Ref: 6/2023/1018/HOUSE
Date: 20/07/2023

HISTORIC BUILDINGS AND CONSERVATION ADVICE

RE: 55 Longcroft Lane, Welwyn Garden City, AL8 6EB

The application is for the erection of a garden room to rear garden to use as a home office & gym.

Page 3 - Proposed Side Elevations

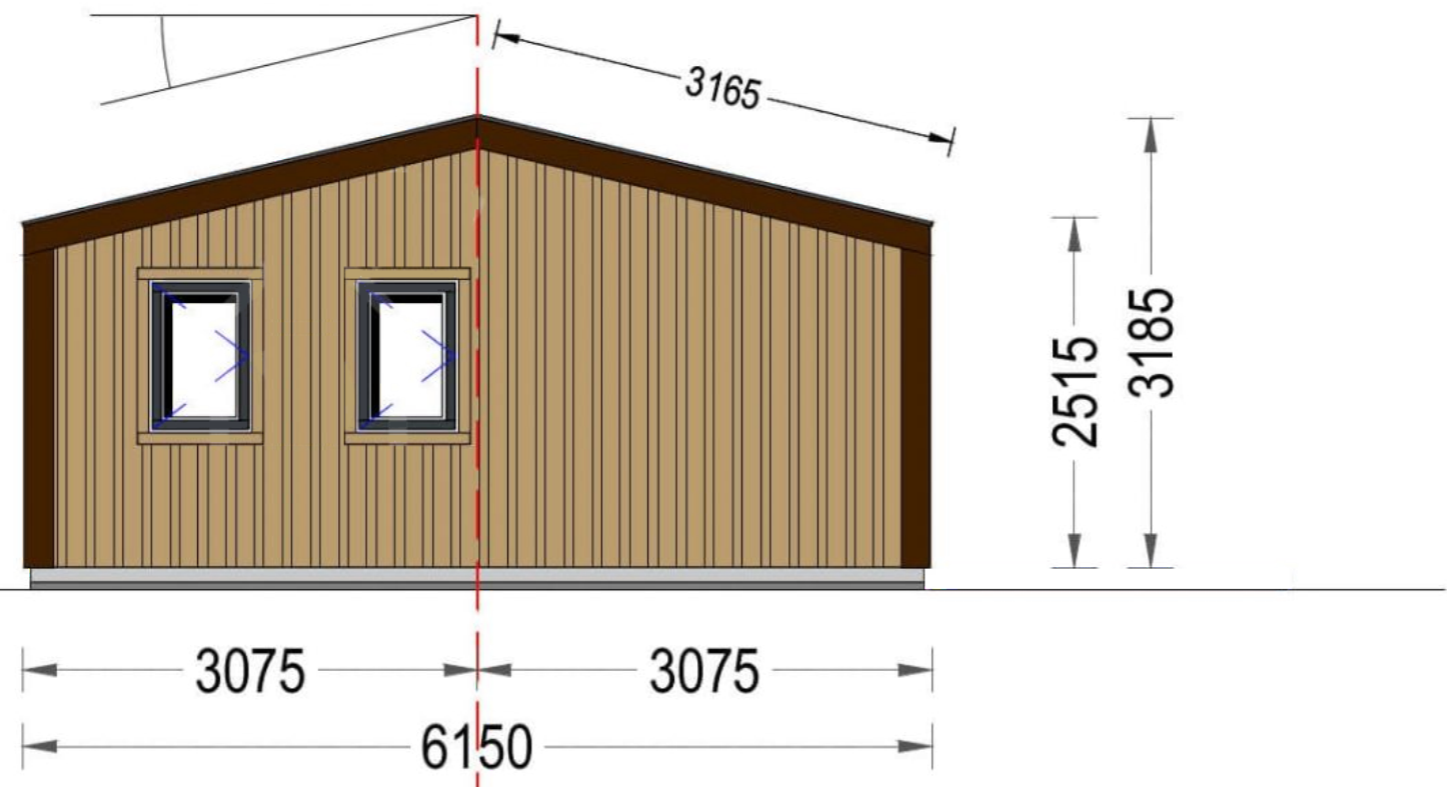
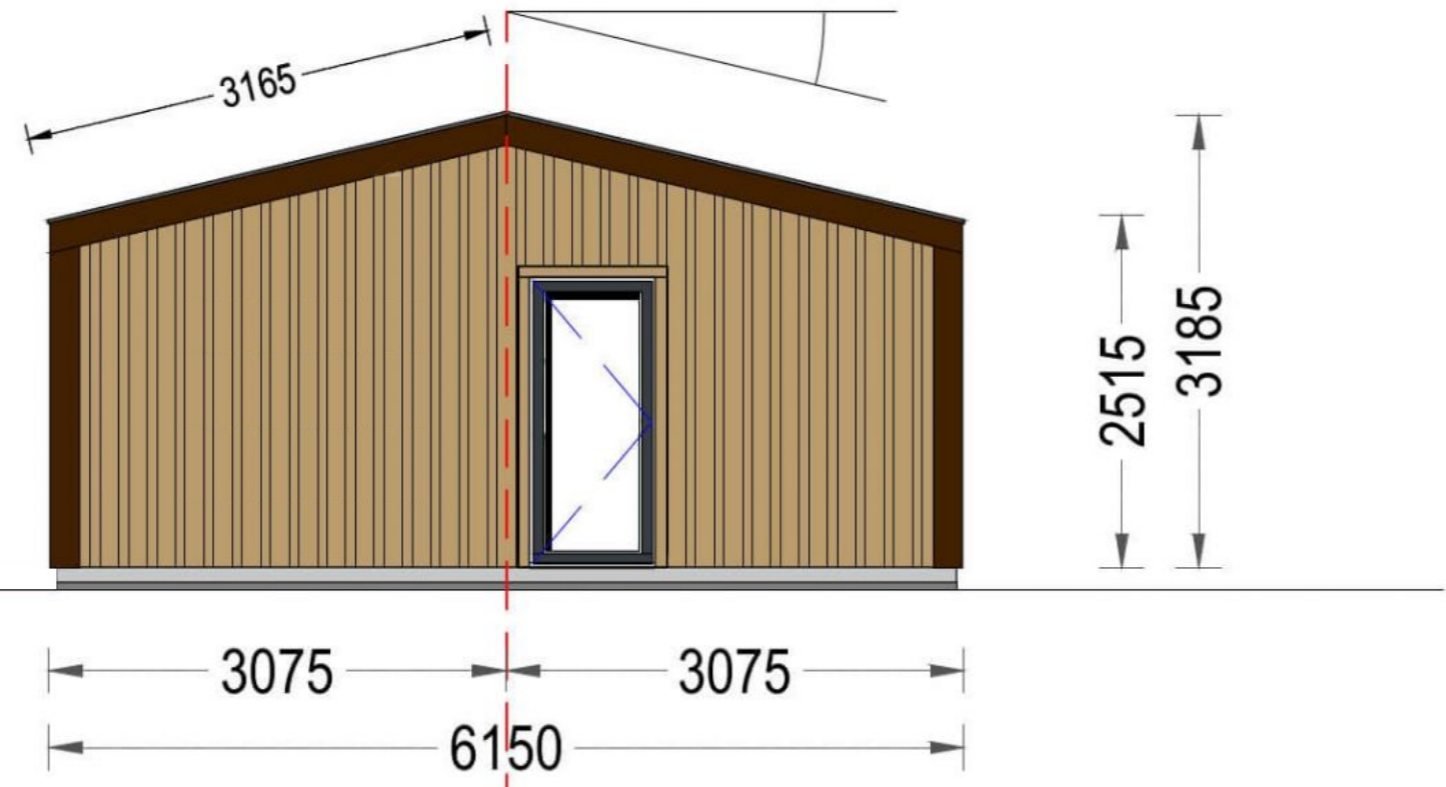
There are no in principle issues with a well-designed outbuilding in the rear garden, however there are concerns that the proposed materials of grey cladding, black felt and grey uPVC windows are not in keeping with the characteristic material palette of the Conservation Area. The typical red clay roof tiles and red bricks contribute strongly to the area's character and appearance.

If the proposed materials are improved to be more sympathetic with the Garden City vernacular there would be no objections to the proposal. Due to the incongruous material palette the proposal is considered to result in the very lowest level of less than substantial harm to the Conservation Area and paragraph 202 of the NPPF is relevant. Consideration should also be given to Section 72 of the Planning (Listed Buildings and Conservation Areas) Act 1990 in which special regard should be given to the desirability of preserving the character and appearance of a conservation area.
